From: Michael Eastham
Sent: 31 July 2019 14:13
To: Planning.Responses <Planning.Responses@arun.gov.uk>
Cc: Nicola Spencer <Nicola.Spencer@arun.gov.uk>
Subject: FW: *EXTERNAL: LU/241/18/PO - Location Plan

From: Michael Eastham <Michael.Eastham@arun.gov.uk>
Sent: 31 July 2019 13:31
To: Sparkes, Jessica [REDACTED]
Cc: Havis, Sean [REDACTED]
Subject: *EXTERNAL: LU/241/18/PO - Location Plan
Importance: High

Please could you amend the attached location plan by:

Client
Gleeson Developments Limited
Project
Courtwick Littlehampton
Description
Plan 2

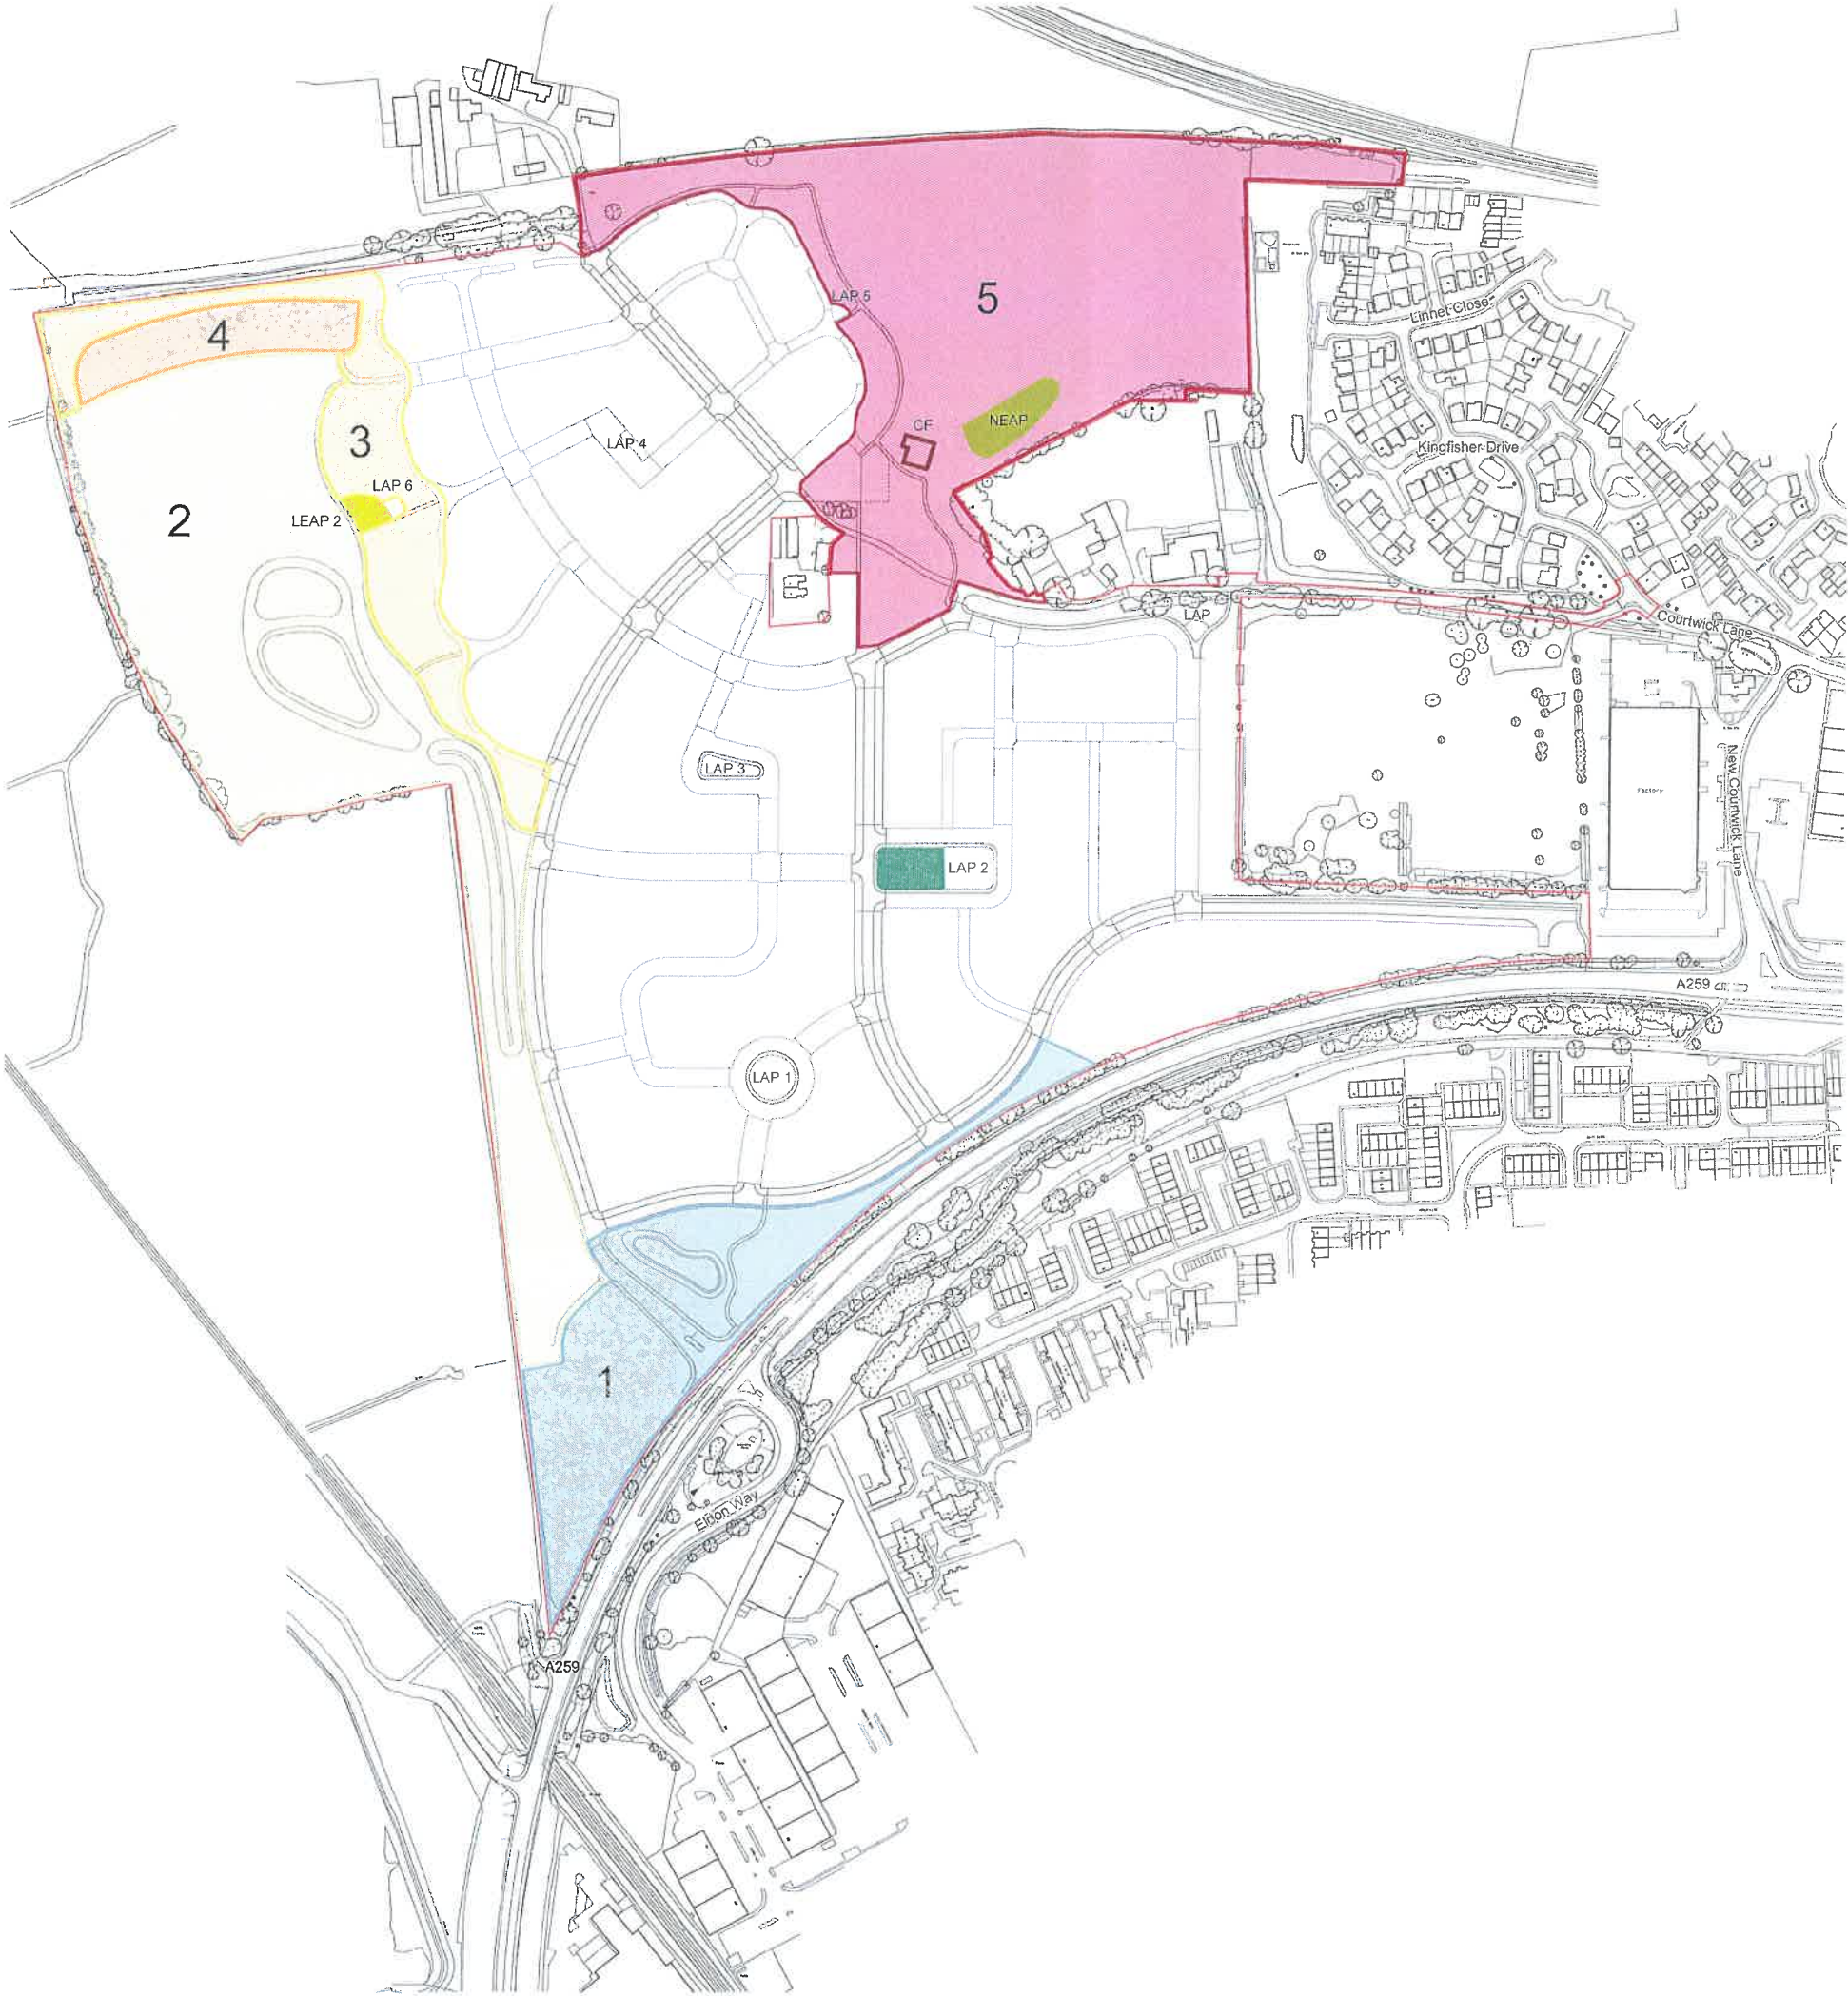
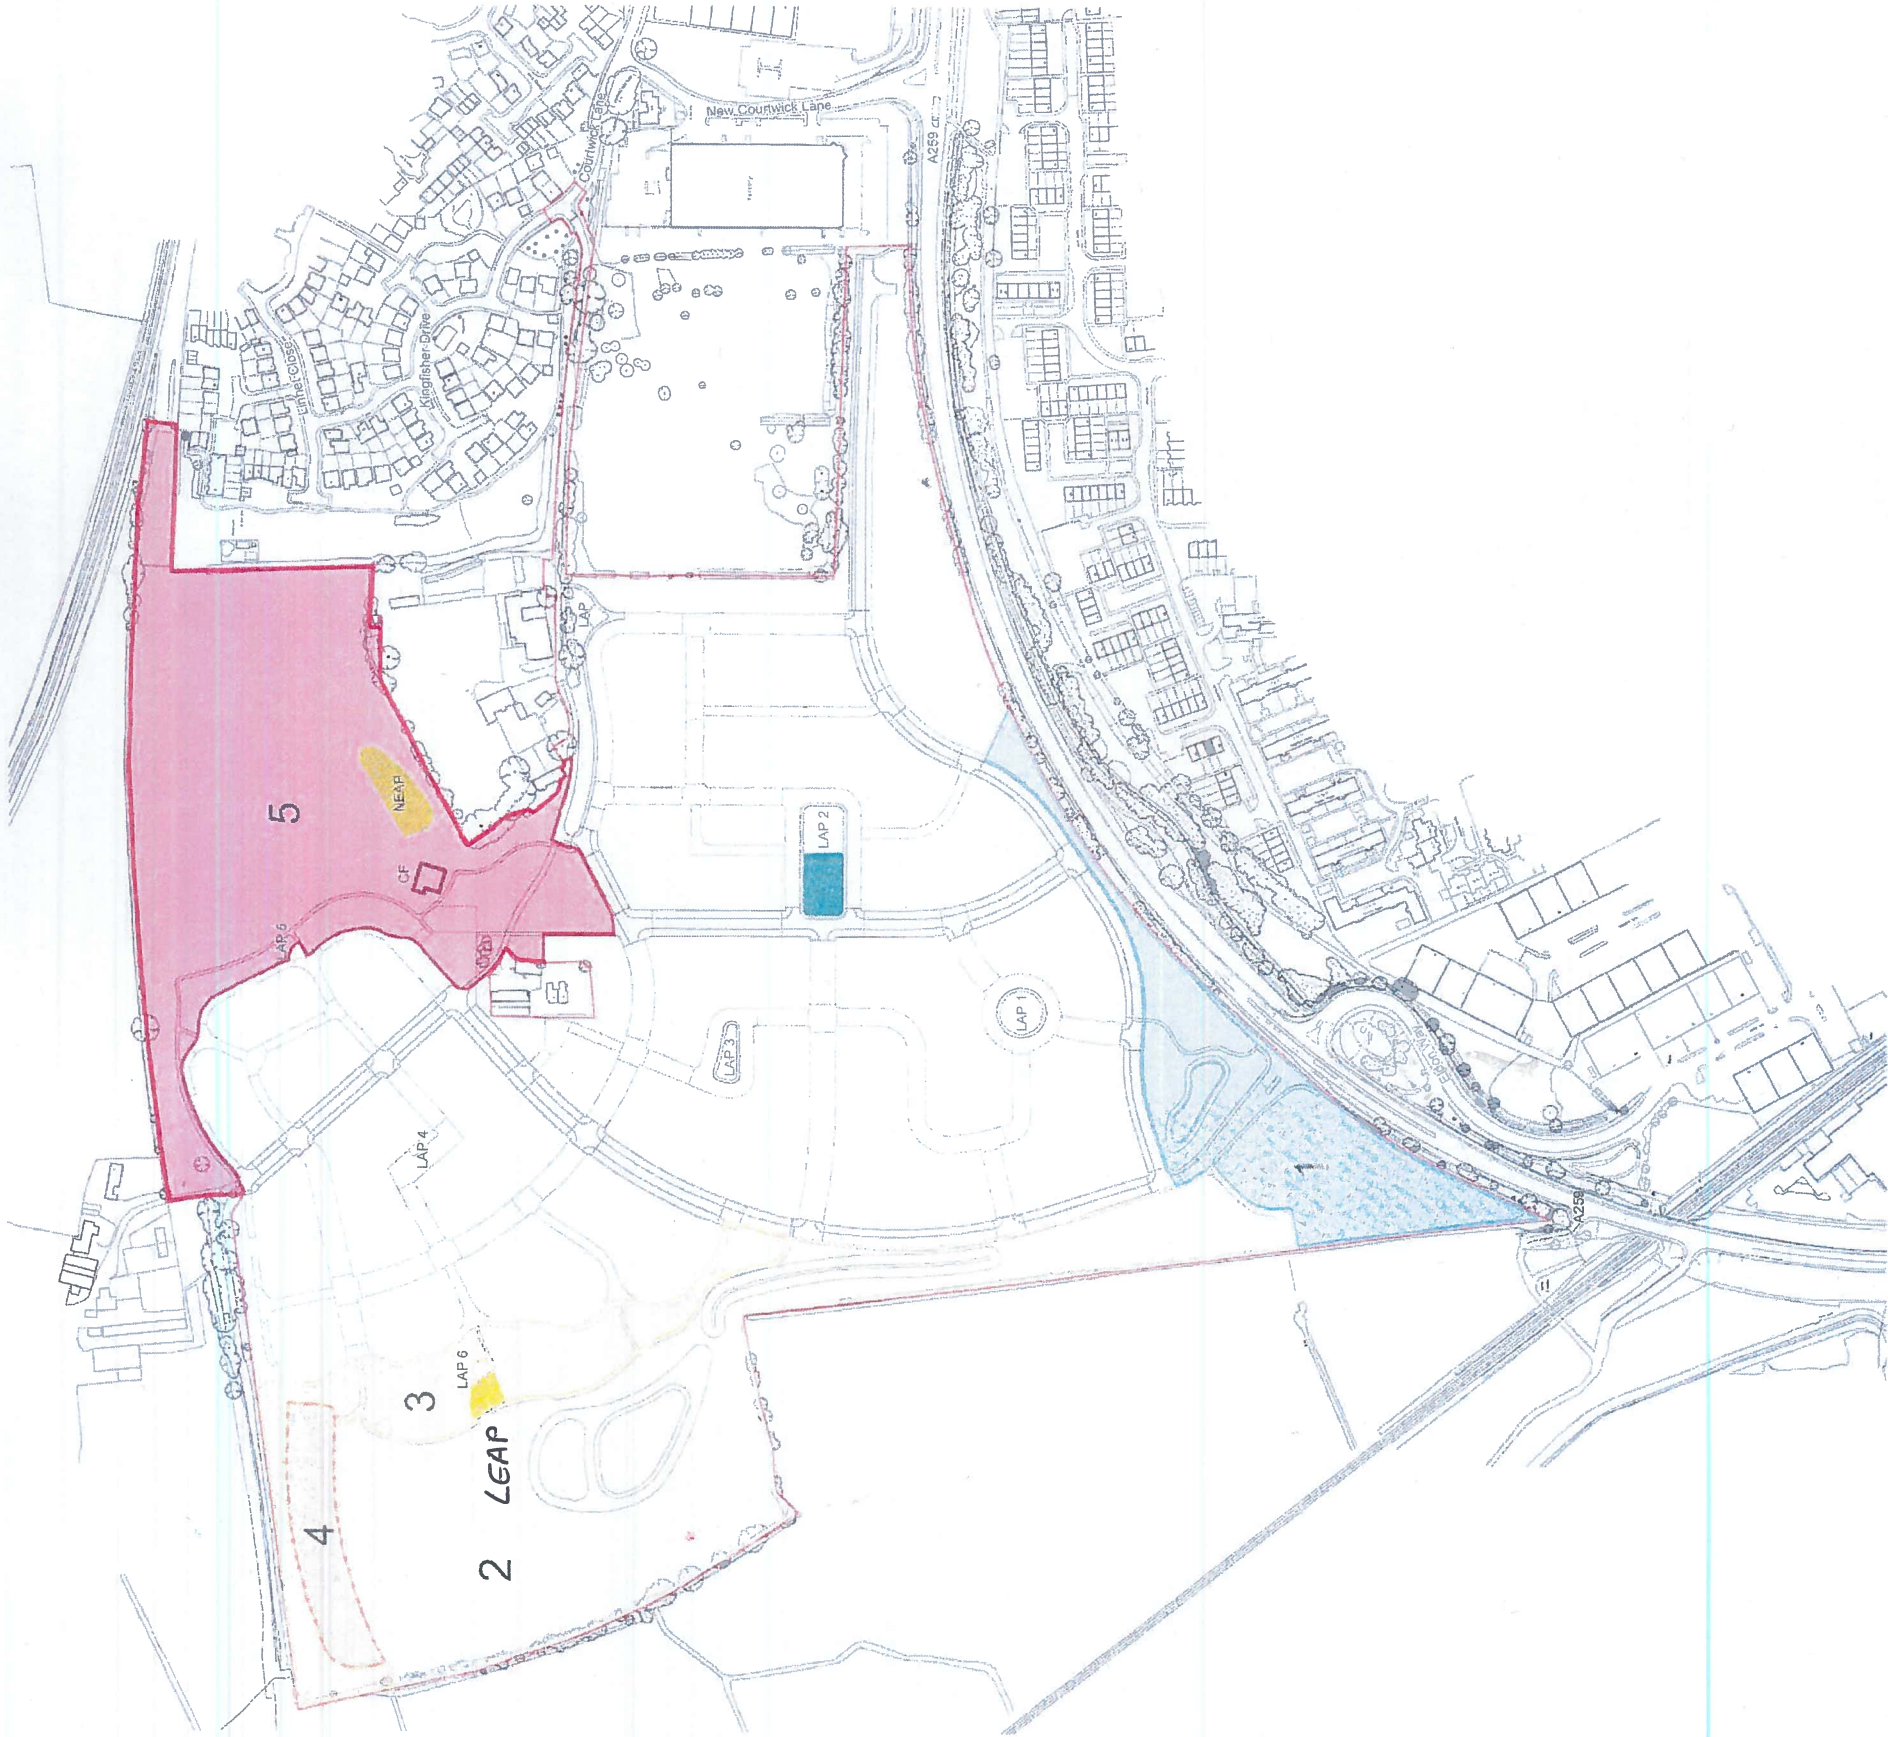
- 1) revising the key to read "LEAP" (i.e. remove "LEAP 2");
- 2) removing "LEAP2" and insert "LEAP" on the plan.

Please find the revised attached plan.
